**Summary of the Written Submission  
Of the  
Royal Society for the Protection of Birds  
and Suffolk Wildlife Trust**

**Submitted for Deadline 2  
2 June 2021**

**Application by NNB Generation Company (SZC) Limited for an Order  
Granting Development Consent for  
The Sizewell C Project**

**Planning Inspectorate Ref: EN010012  
RSPB Registration Identification Ref: 20026628  
Suffolk Wildlife Trust Registration Identification Ref: 20026359**

DRAWING NO:
SZC-SZ0100-XX-000-DRW-100205

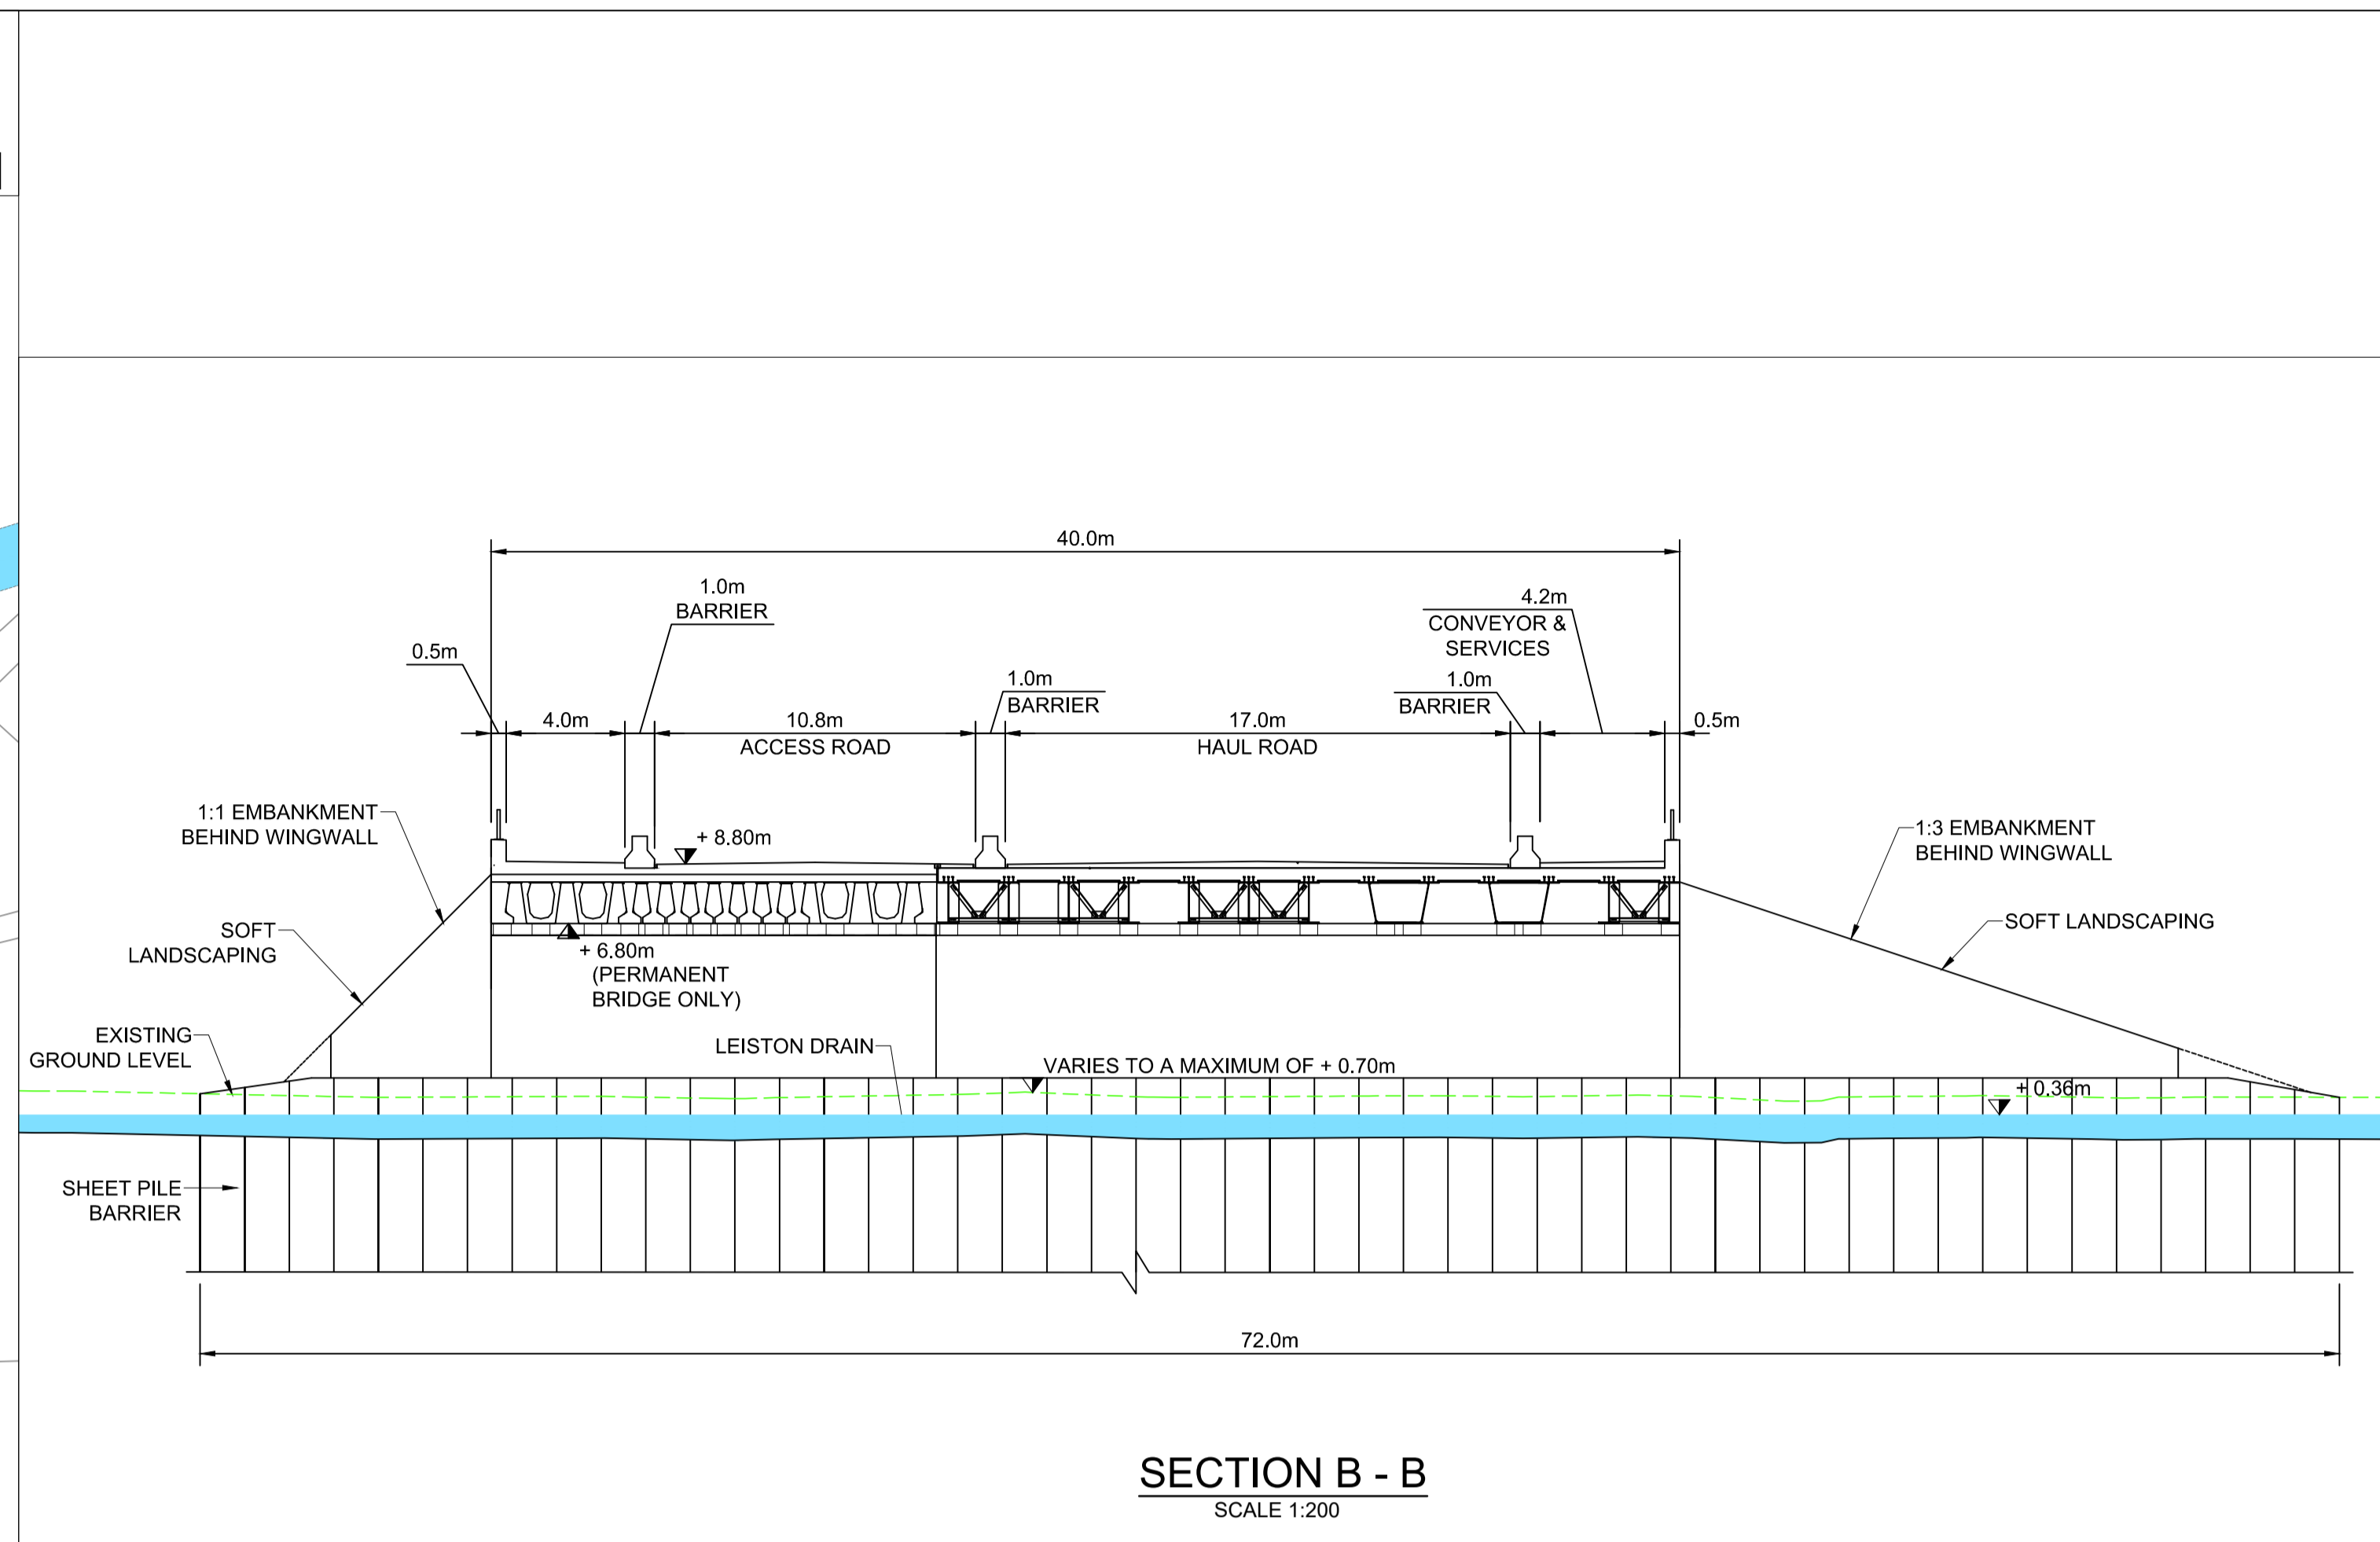
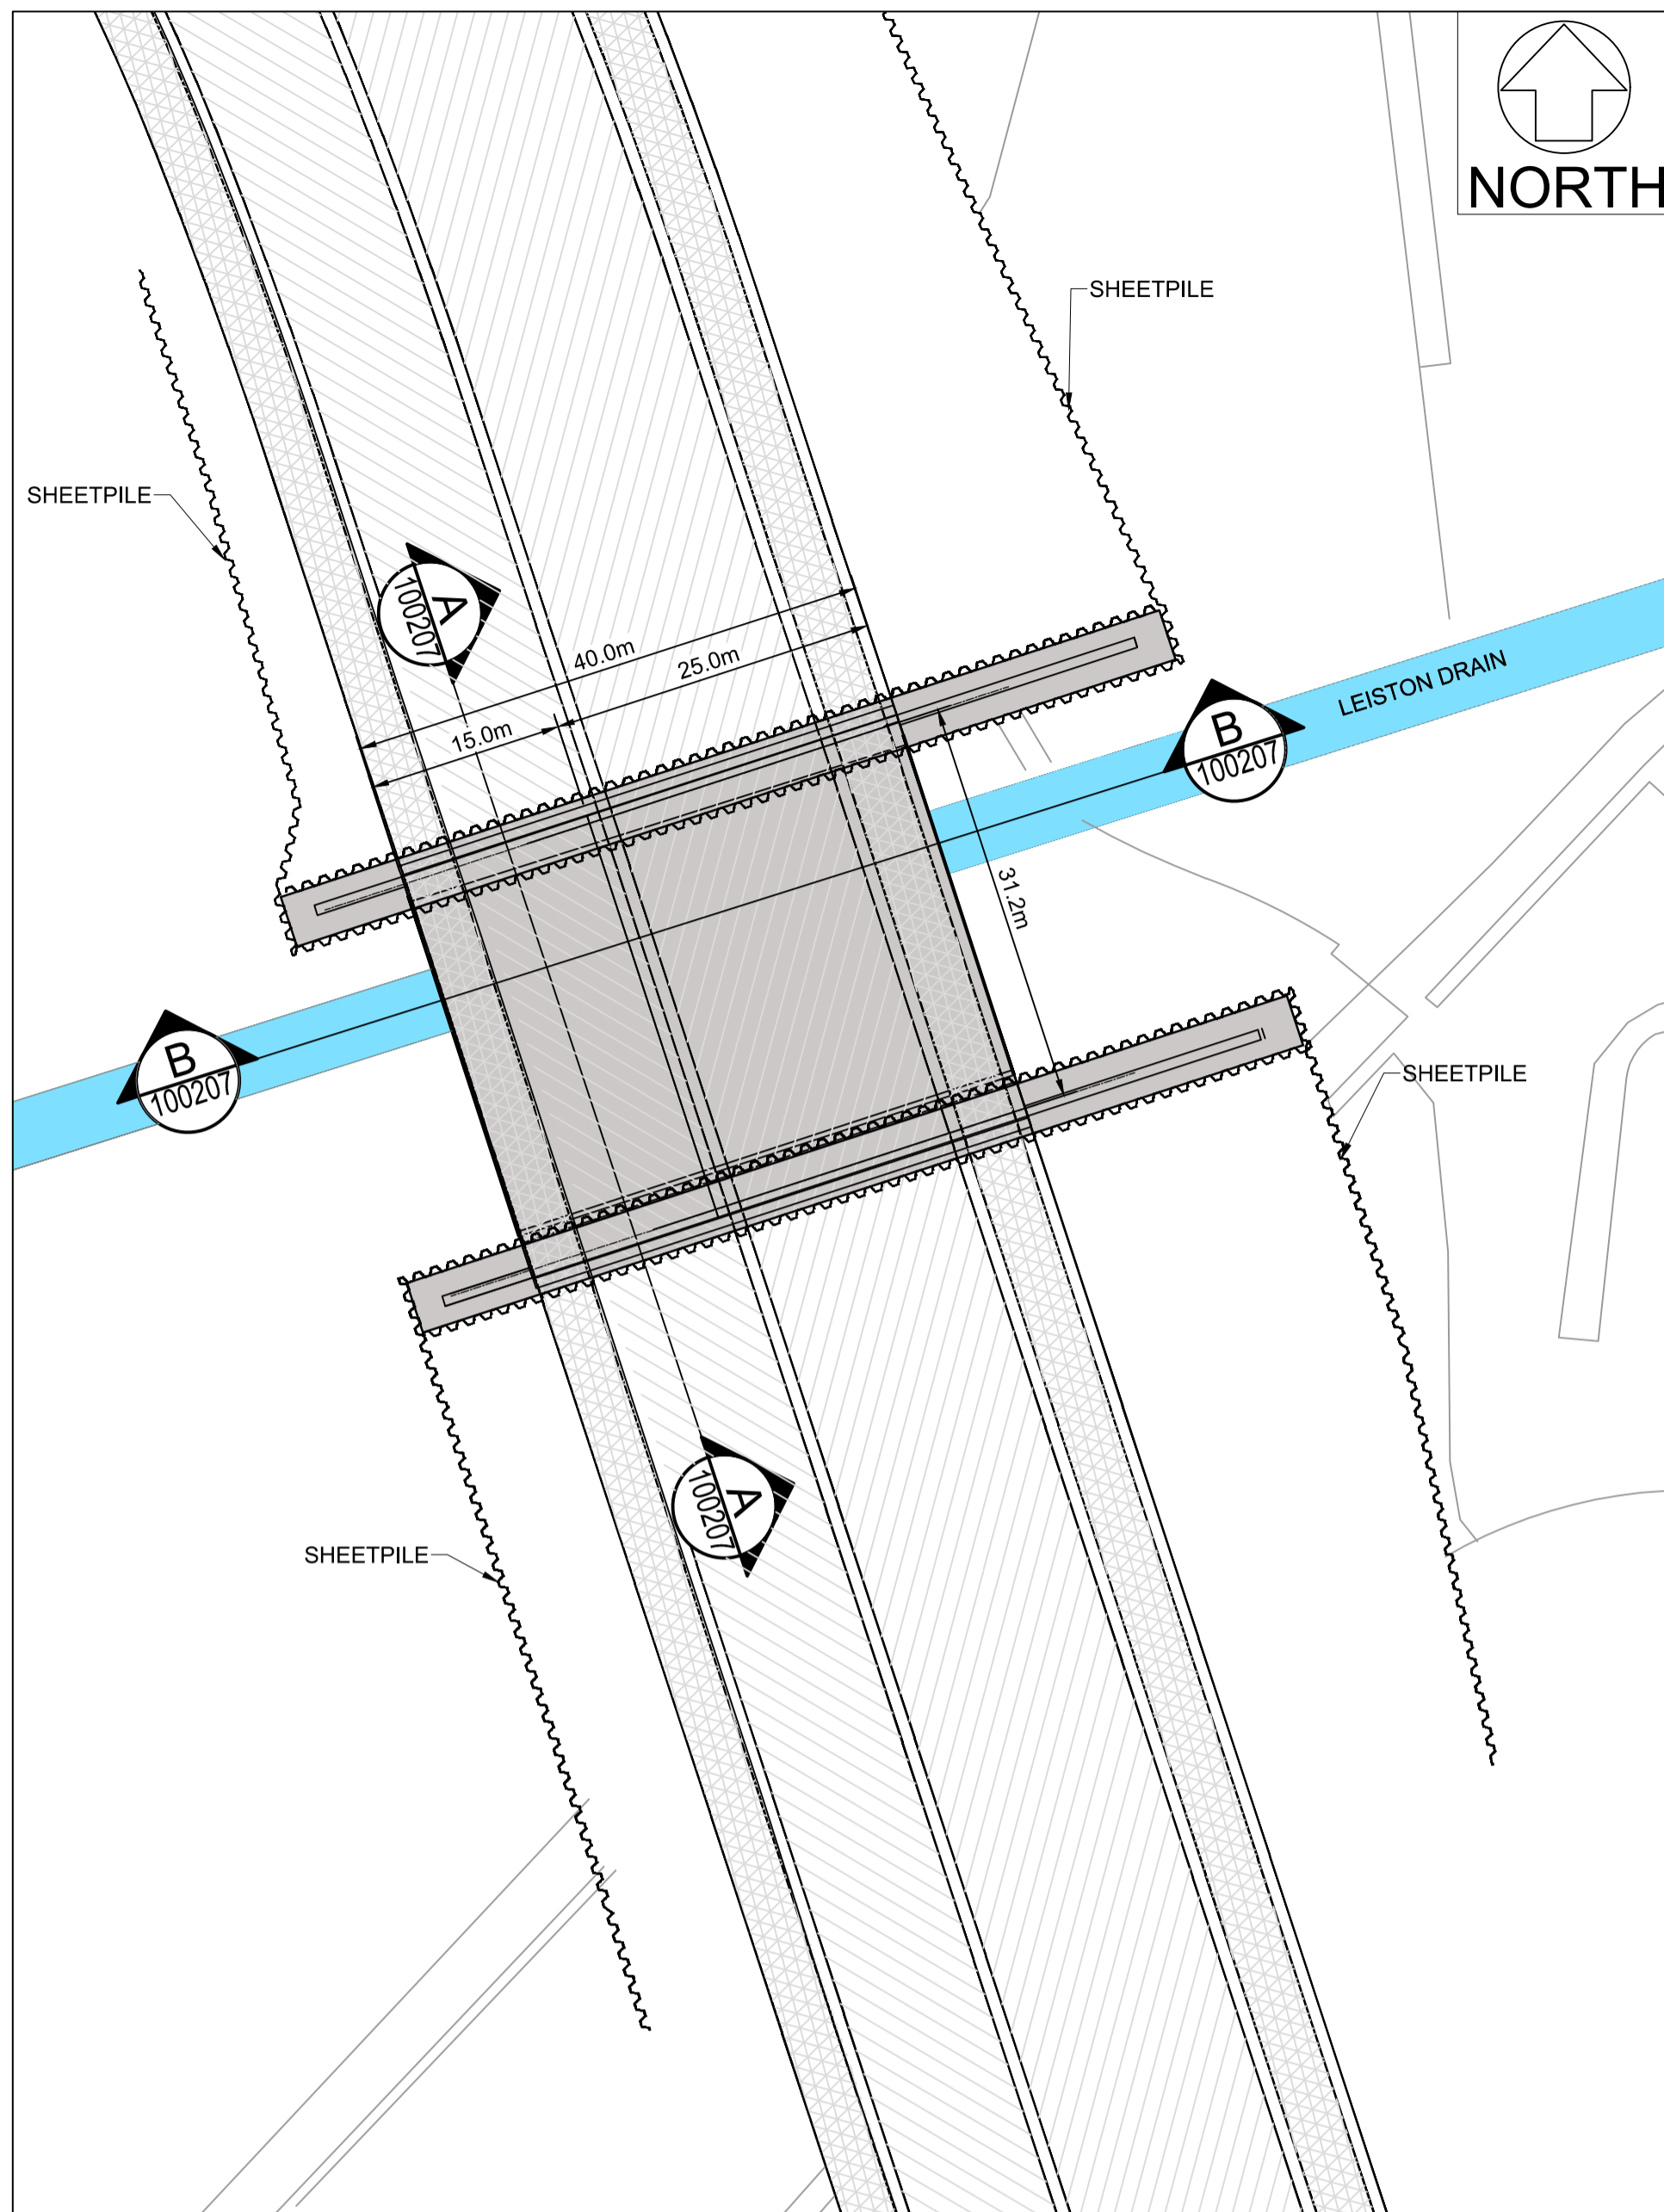
In addition, we are unconvinced about the Applicant's justification for the choice of an embankment and culvert (a single span 'bridge') rather than a triple span bridge to cross Sizewell Marshes SSSI, despite the higher land take from the SSSI. We are concerned that the loss of SSSI via the embankment/culvert option will lead to a much larger loss than the triple span bridge option, and this has not been adequately nor clearly justified. We consider the Applicant should assess and compare the impact of all four options for the SSSI crossing and provide sufficient evidence for Natural England to advise the Examination on any effects on the special interest of the SSSI. Also, a detailed design for the SSSI crossing has not been submitted to the Examination.
